Ref: Planning Application R/2/14 – 1 Merton Avenue, Rustington

With reference to the above planning application, we are writing to object to the planning application for that property.

proposed rear elevation

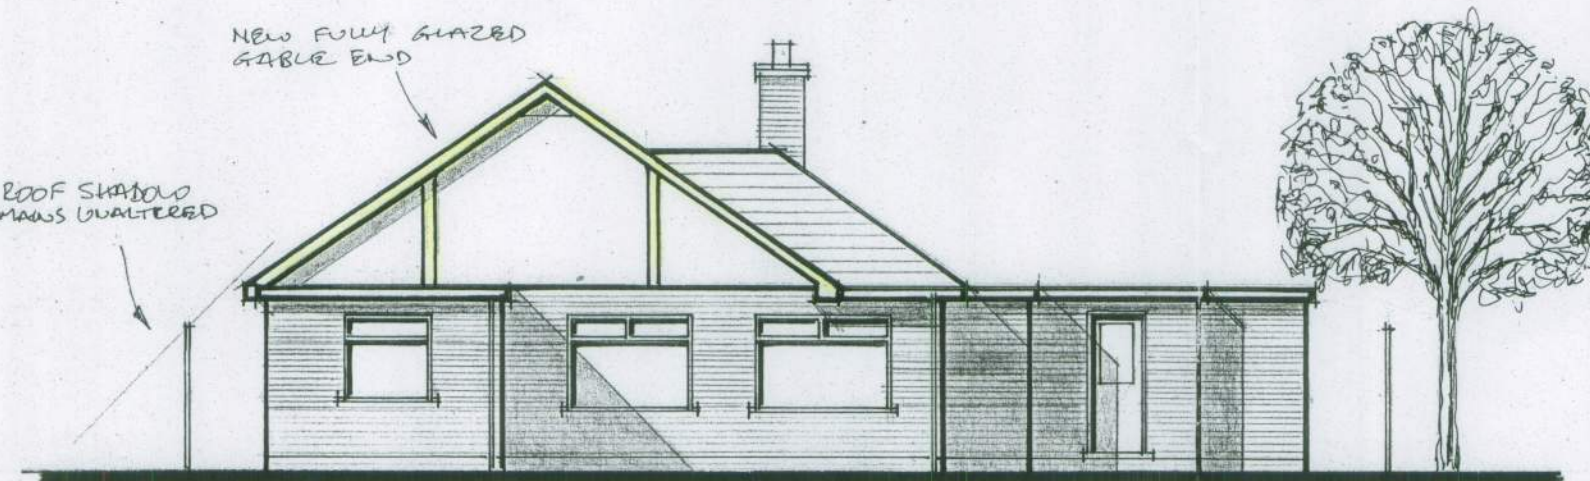
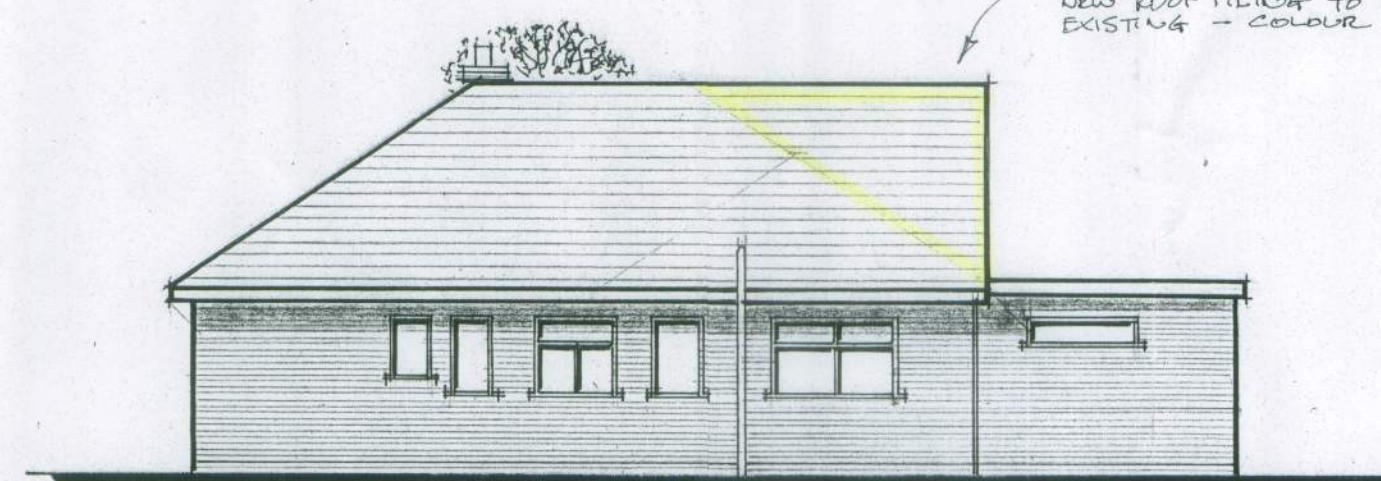
Looking at the plans, we feel that the **glazed** gable end will definitely overlook our garden interfering with our privacy. The "existing tree screening" to the rear of the property is, in fact, a hedge which, we feel, does not provide adequate screening.

Where our bedroom is situated on the side of our bungalow, the view from the glazed gable end of 1 Merton Avenue, Rustington, the occupiers will have a clear view directly into our bedroom. We do not feel obliged to have to keep blinds/curtains shut in order to have our privacy. This is apart from the view the occupiers will have directly into our garden.
